CITY OF ALBUQUERQUE

Re: Manual Shops
7212 Manual Blvd 87110
Request for Certificate of Occupancy
Transportation Development Final Inspection
Engineer's/Architect's Stamp dated 6-3-19 (H19D040)
Certification dated 7-27-20

Re: 7212 MENAUL Blvd NE
Alley

Re: Manual Shops
7212 Manual Blvd
Alb. NM 87110
BP-2019-34287
Engineer's/Architect's stamp dated: 06-02-2019 (H19D040)

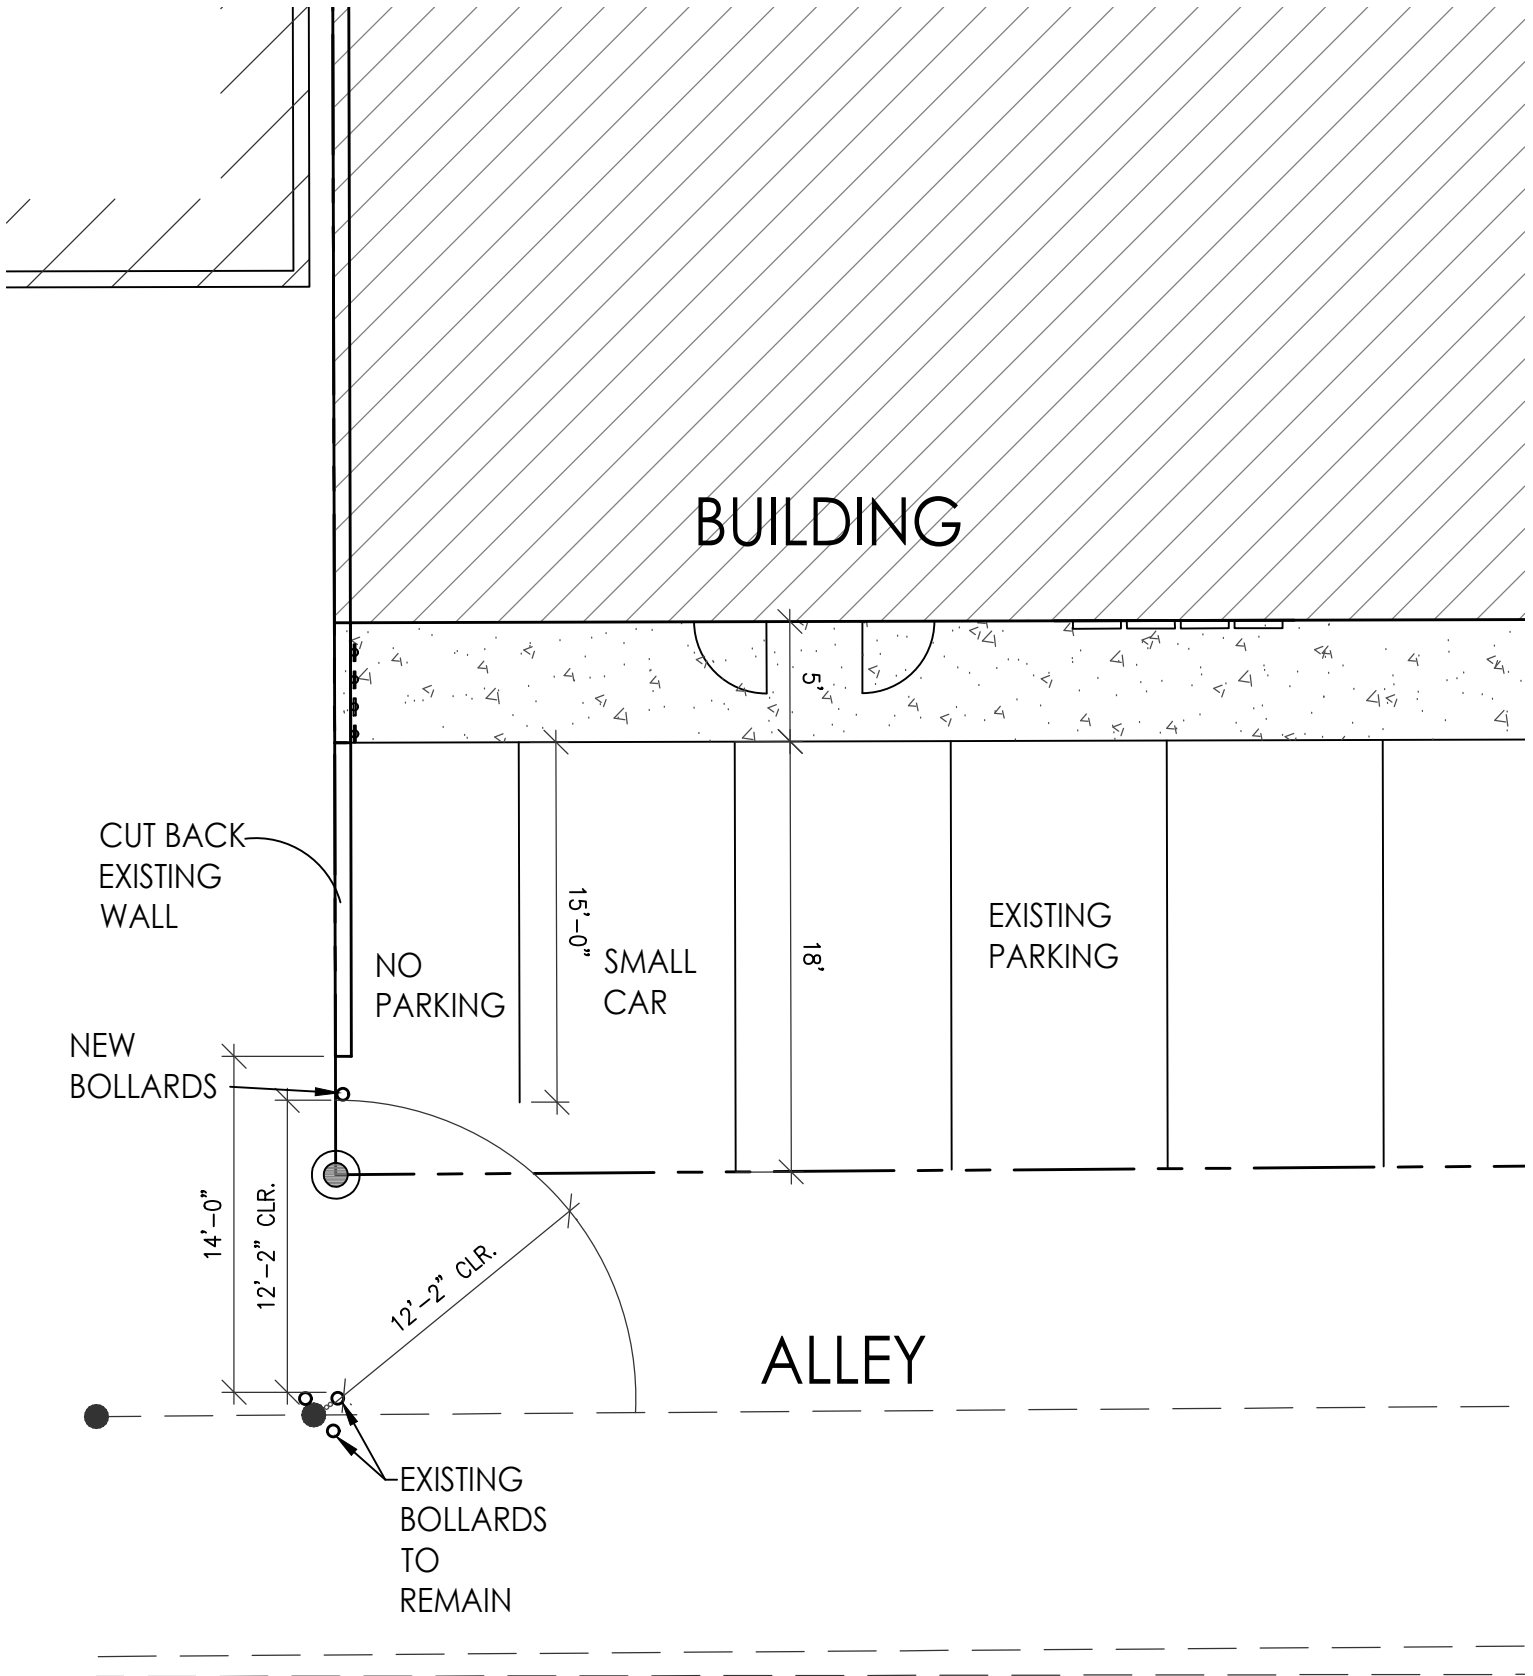
Thank you for working with us on the south alley at 7212 Menaul.
We will cut the wall back and eliminate one parking space and convert one regular space into a small car space. The clear opening will not be less than 12'-0" from the existing bollards to the new bollard installed to protect the wall. There will be 12'-0" clear at all points north of the power pole (see attached drawing).
